Harnett County
420 McKinney Pkwy
LILLINGTON, NC 27546
Phone:
Fax:

SUBJECT: SFD2110-0084
SINGLE FAMILY DWELLING

Here are the results of all Inspections located at **1683 JOSEY WILLIAMS RD:**

FIELDCREST MODERN FARMHOUSE / CUSTOM  
 FIRST FLOOR JOIST PLAN

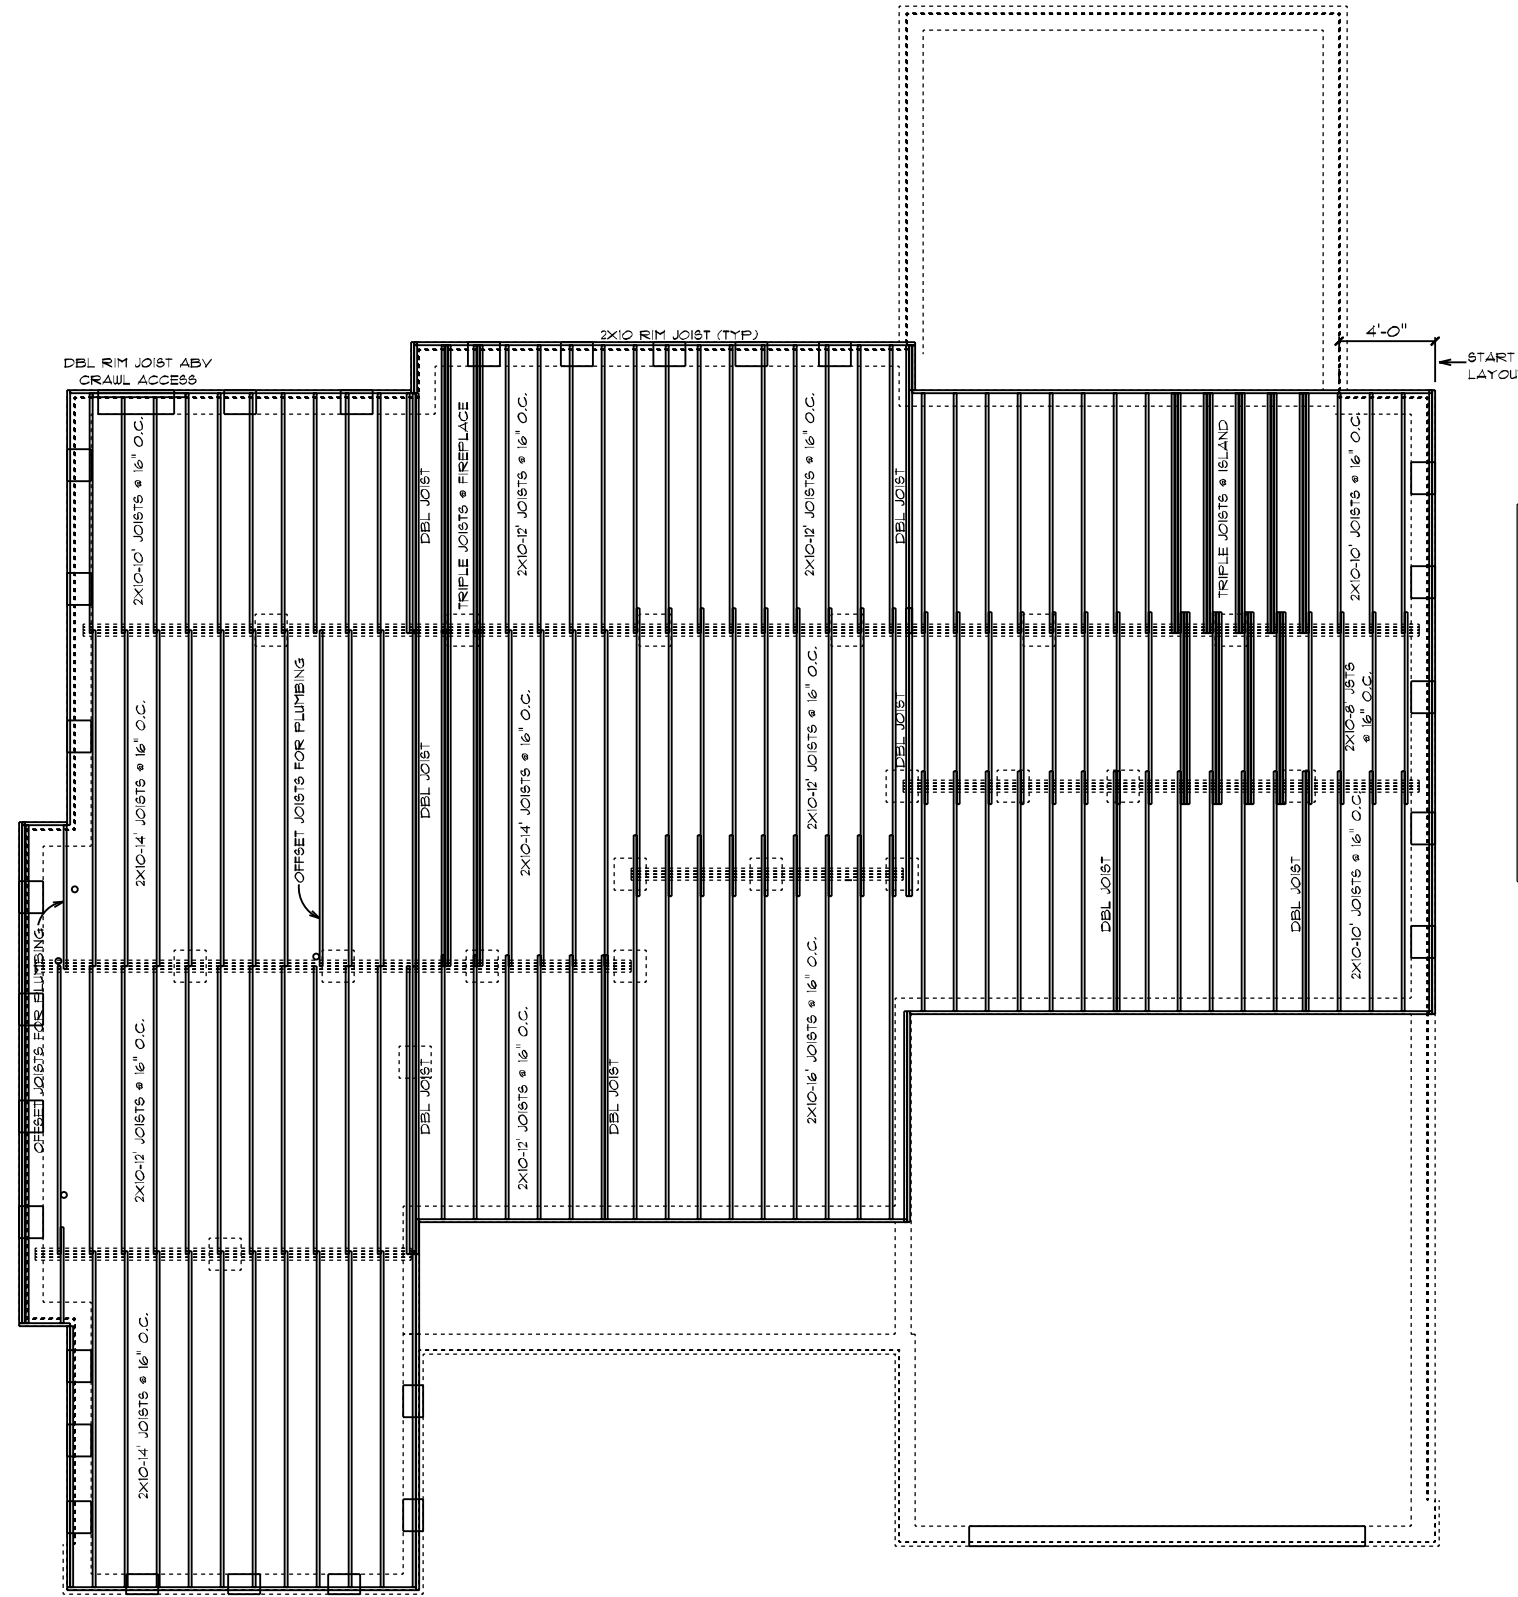
Floor joist cut in half by rear double doors.
Rear porch post not installed at time of inspection.
Need to fire block chase between great room and morning room.
Need to fire block fireplace.
blocking should have been up by the osb board.
Need to seal air barrier in upstairs both bathroom behind showers

**FIELDCREST MODERN FARMHOUSE / CUSTOM**  
 FIRST FLOOR PLAN  
 9' CEILING HEIGHT

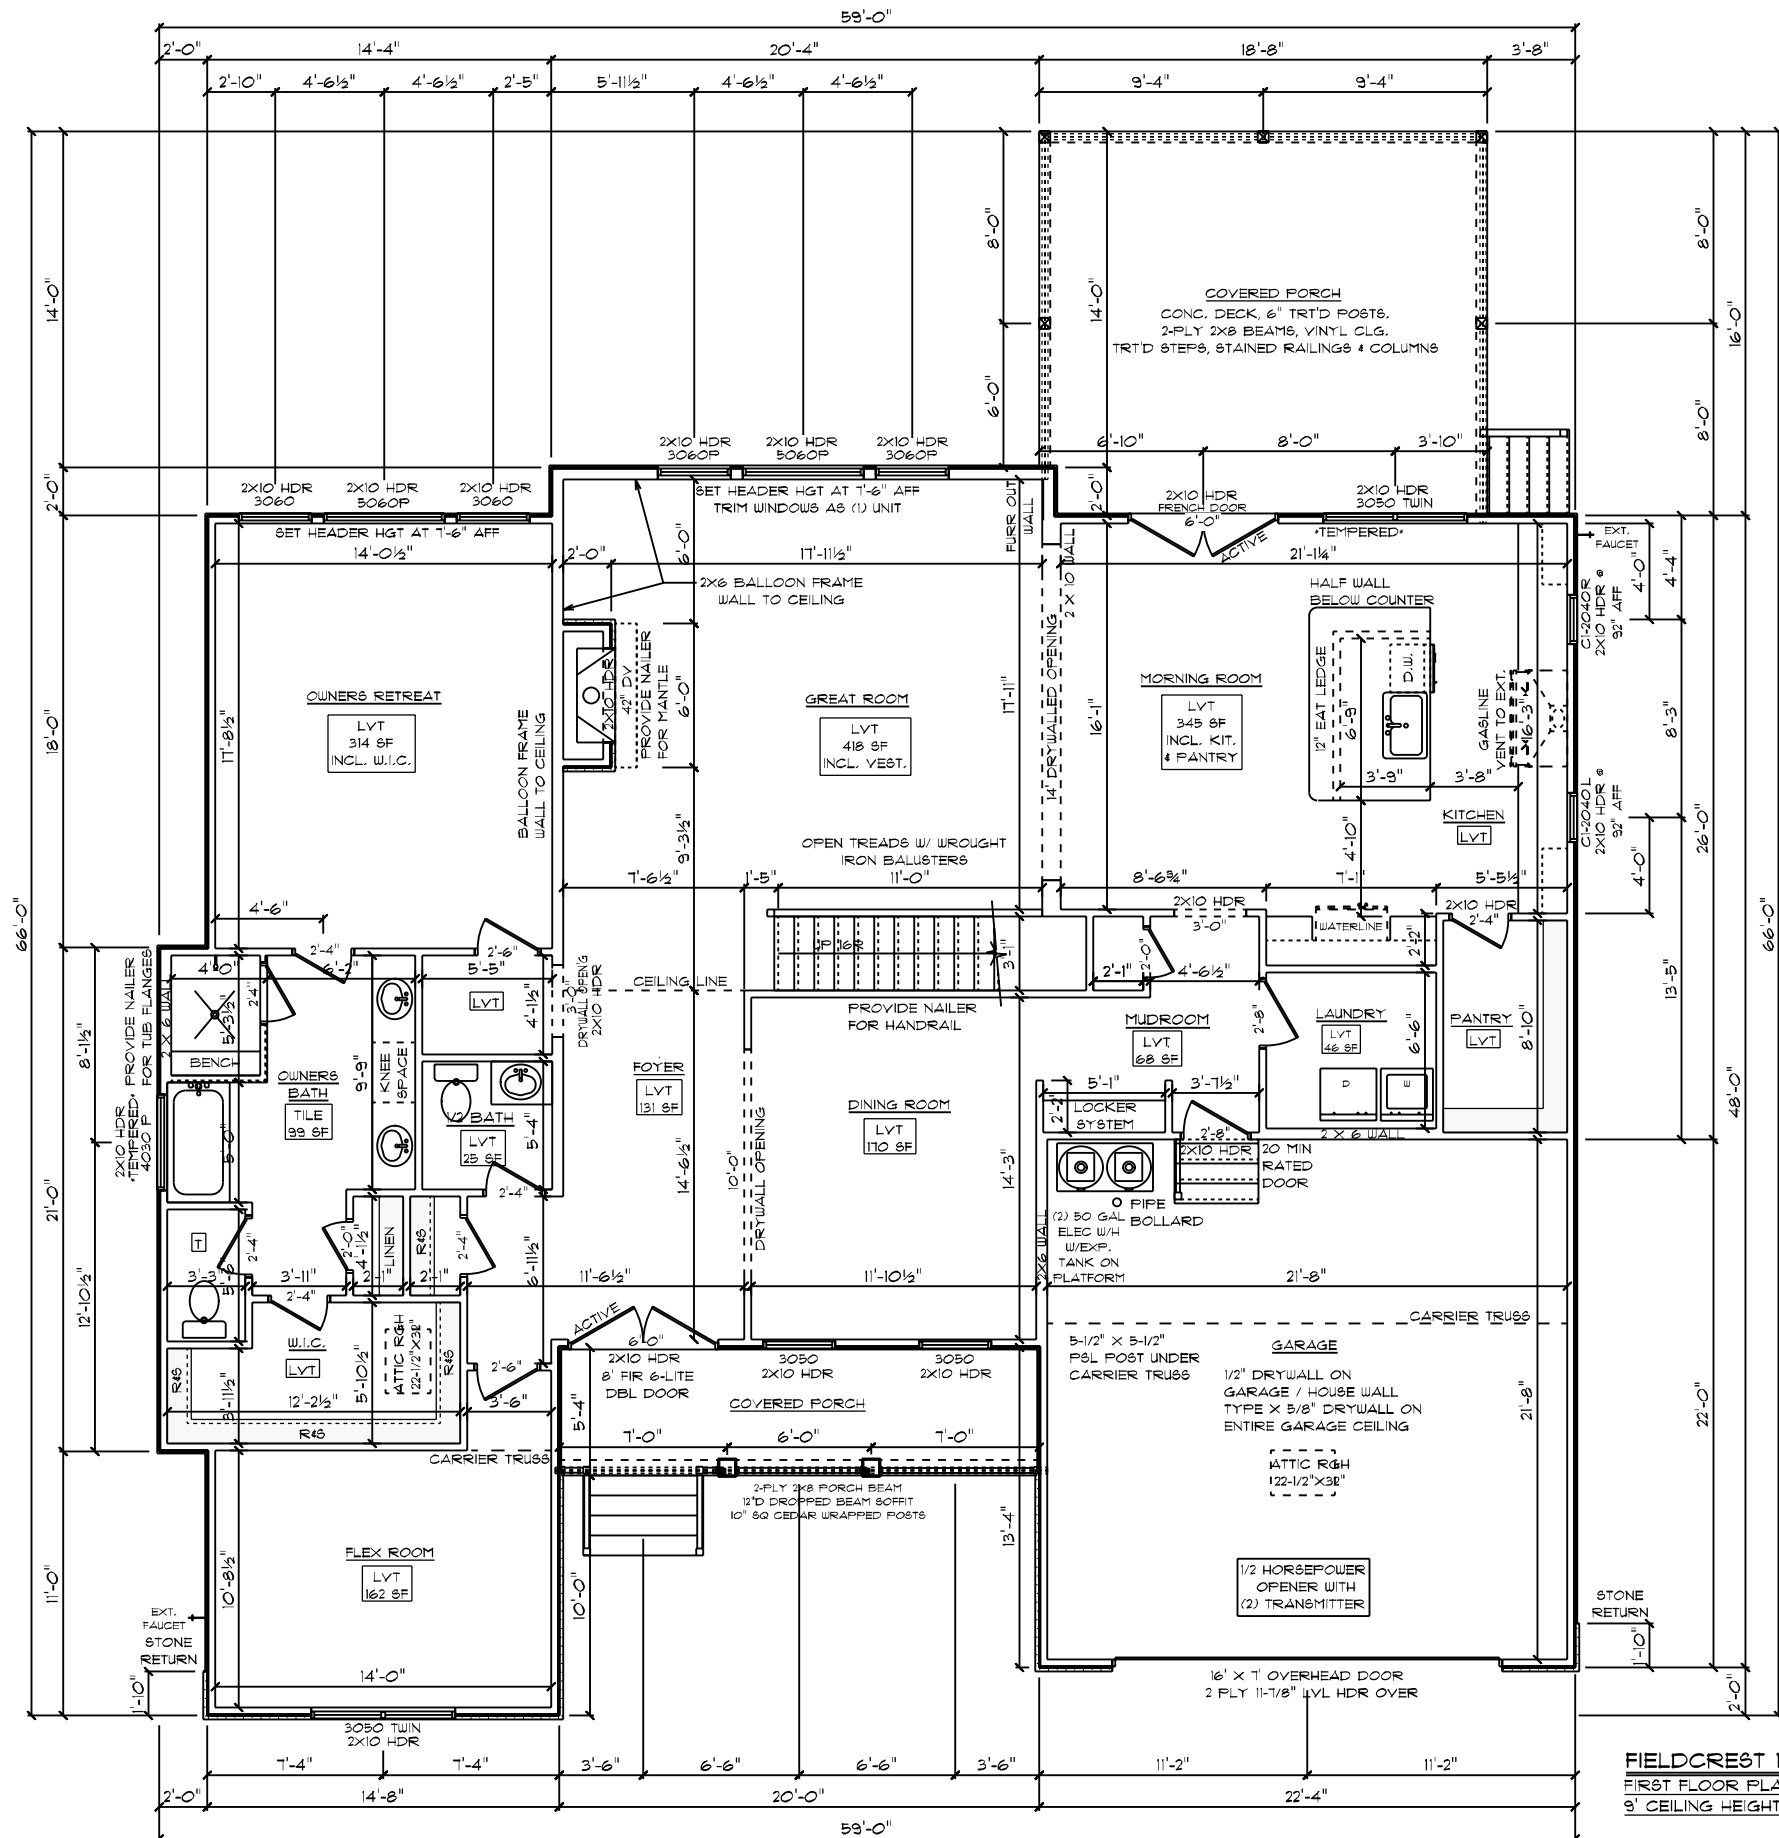
Need to insulate trap in garage
Need a King studs bear solid left side of the garage
Need to seal all openings for garage to habitable space
Floor joist cut in half by rear double doors.
Rear porch post not installed at time of inspection.
Need to fire block chase between great room and morning room.
Need to fire block fireplace.
Need to add King stud on right side of master window
Need to support 4 gang boxes living room, master bathroom
Upstairs loft window needs 1 King stud on each side.
Ok to insulate
